Your Ref: OWPC22291
Our Ref: FG/29/19/PL 15-03-2019
Please ask for:
Mrs A Gardner

23rd April 2019

Erection of 1 No. 2 bed dwelling
South Point 1 Beehive Lane Ferring

Proposed Site Plan, Location Plan,
and Context Plan

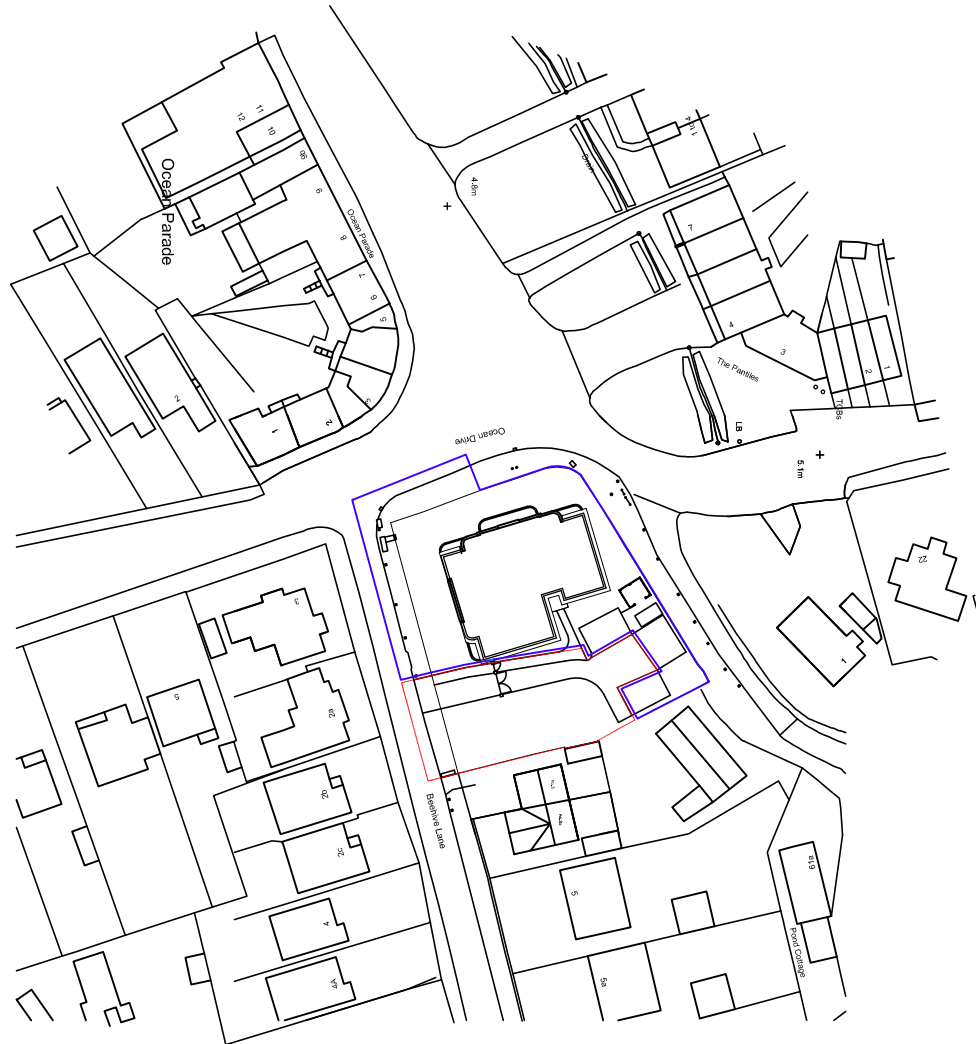
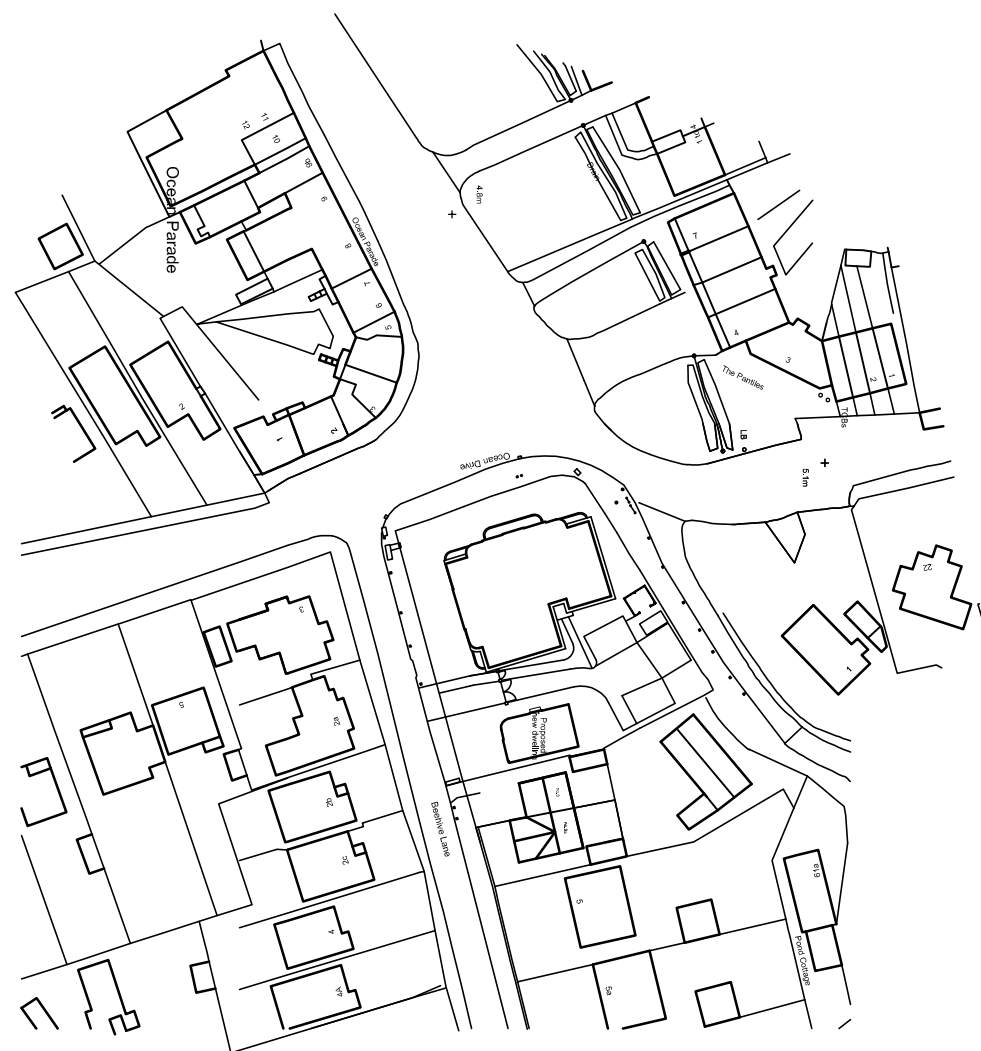
I object to this application because of the loss of the open space between the 8 new flats and 3 Beehive Lane. This was approved as an acceptable buffer between the flats and 3 Beehive Lane.

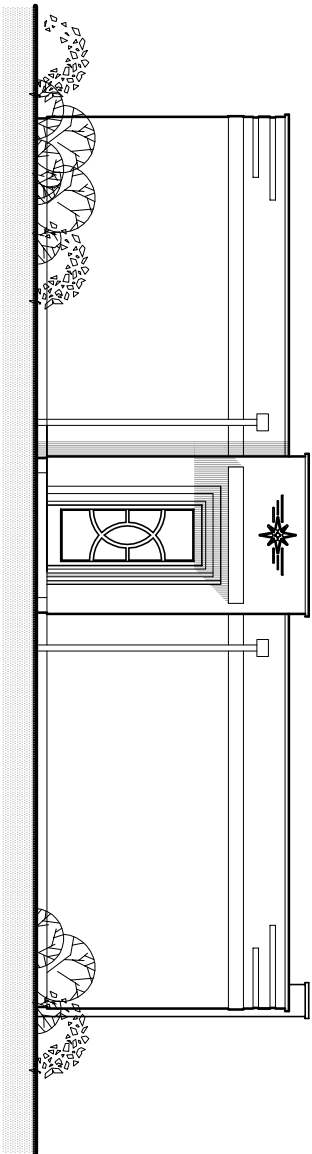
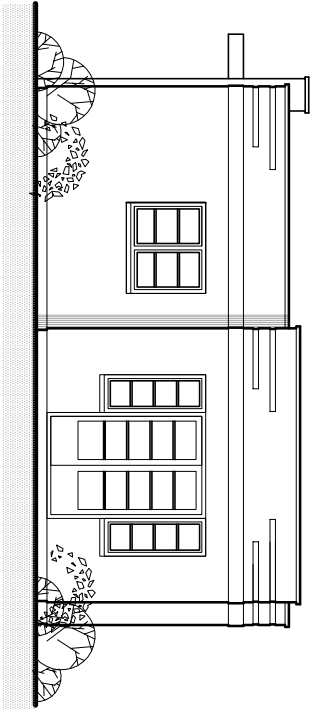
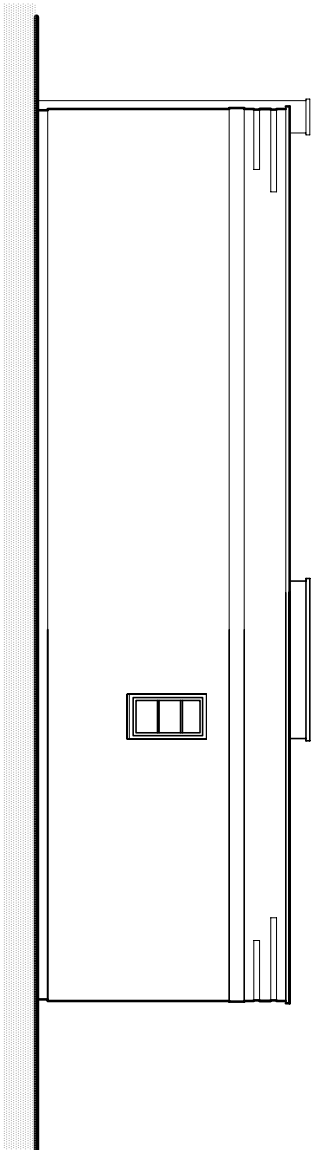
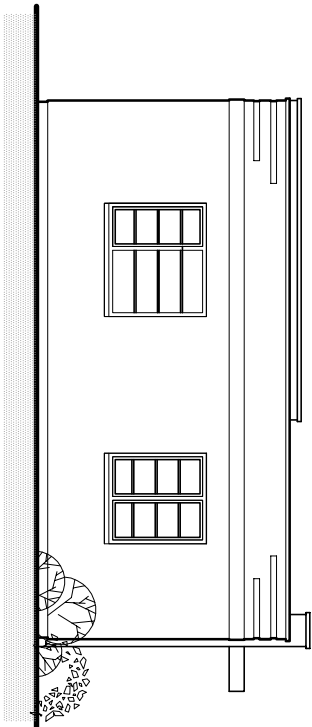
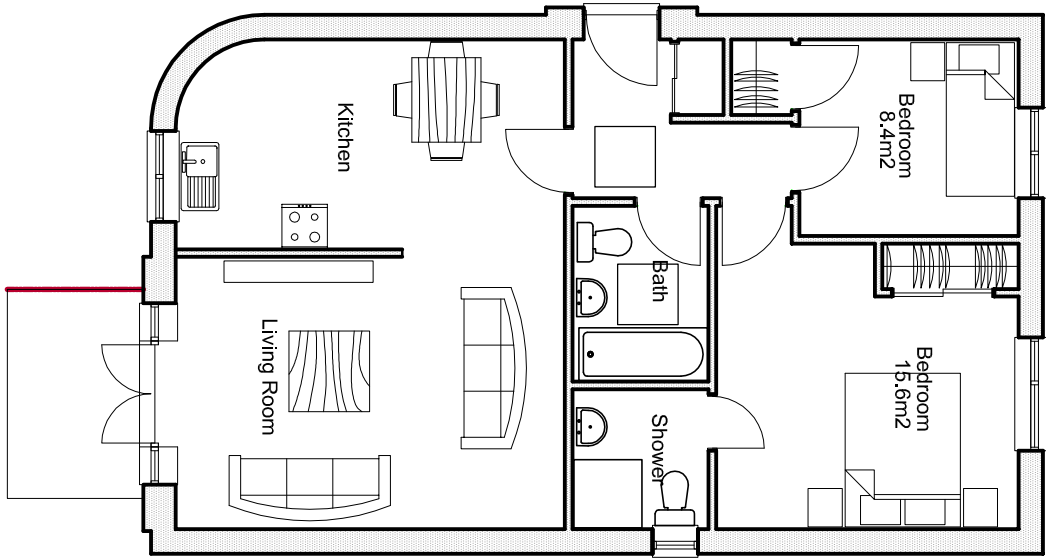
I also object to the increased depth and the object appearance of this building so close to 3 Beehive Lane.
